**REQUEST**

Current Zoning: O-3 (office)  
Proposed Zoning: MUDD-O (mixed used development, optional)

The petition proposes redevelopment of parking decks and modifications to existing development to accommodate additional mix of uses including residential, medical office and retail in addition to the existing EDEE use and office buildings on the site in South Park.

SouthPark Towers PropCo, LLC

RZ-101

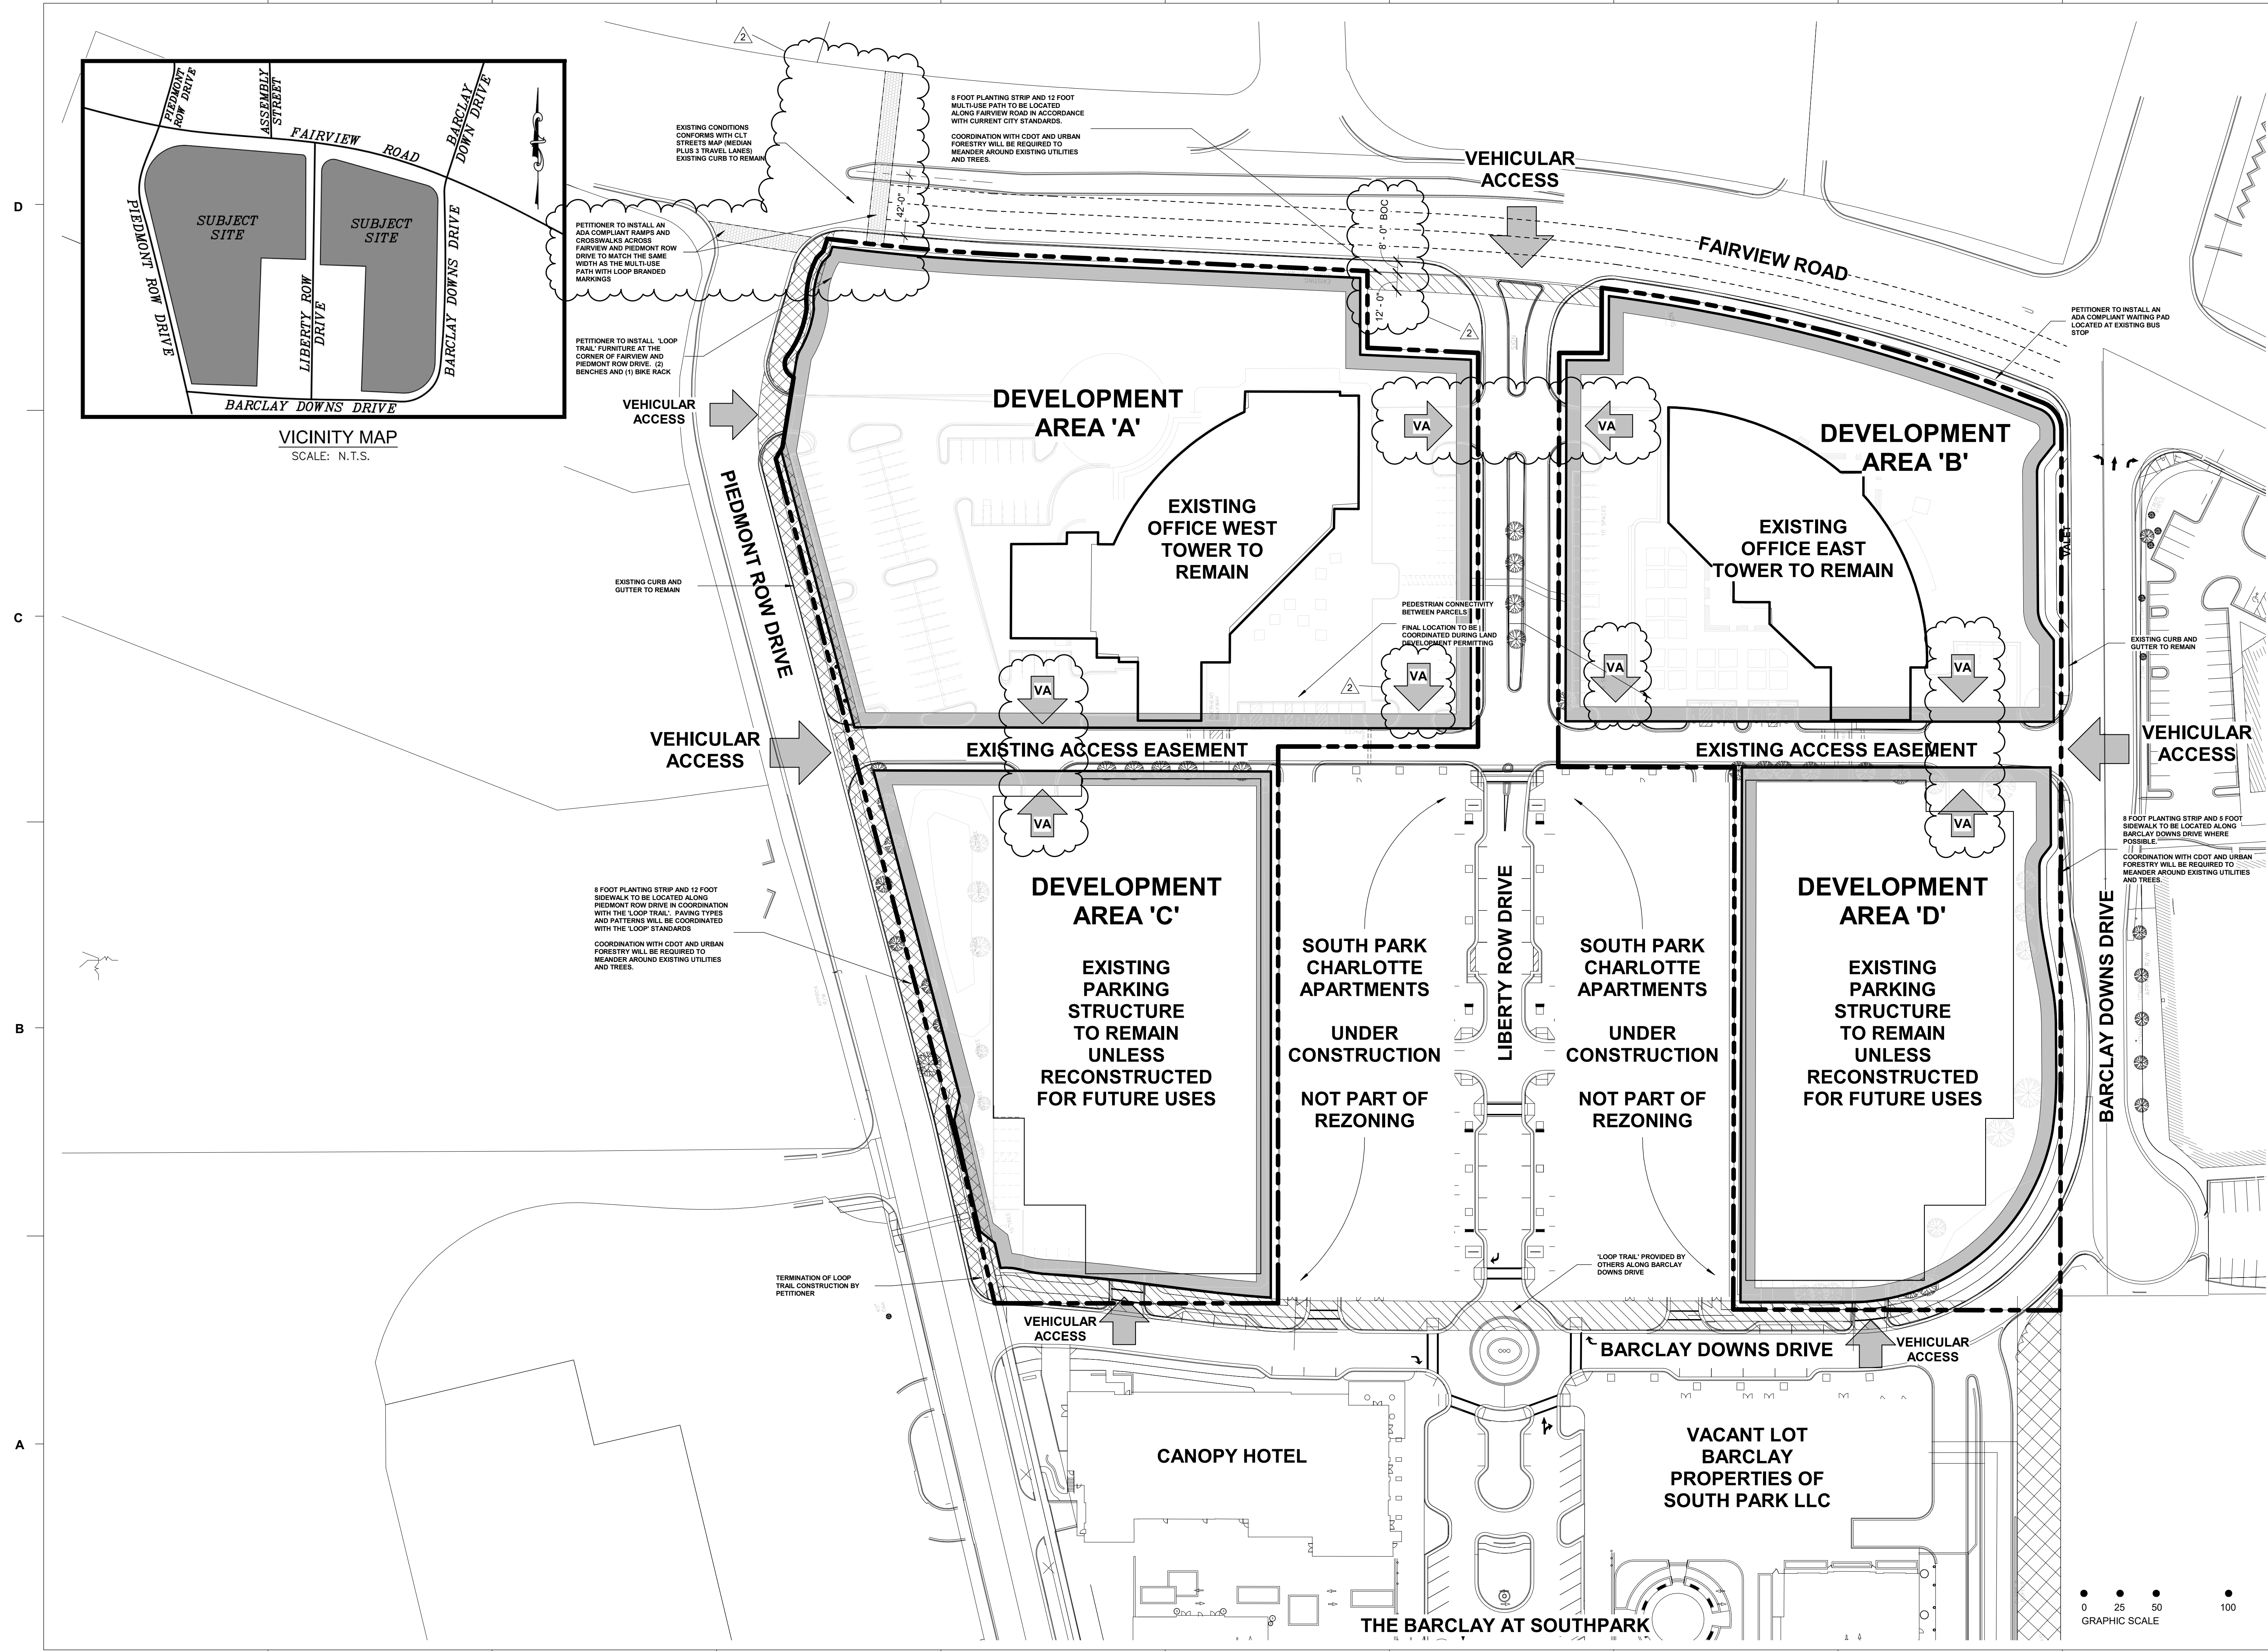
1. Revise site plan and conditional note(s) to commit to dedicate 63 feet of right-of-way from the Fairview Road centerline. The site plan shall label and dimension the right-of-way from the road centerline.
2. Update conditional note V.d.ii.iii. to change "WB" to "EB" as the southern crosswalk is along the eastbound direction on Fairview Road.

4. Amend the optional provision #2 related to existing parking to include Area B as there is existing parking between the building and Barclay Downs Dr.
5. Include note that any changes to the existing buildings will not increase their degree of nonconformity.
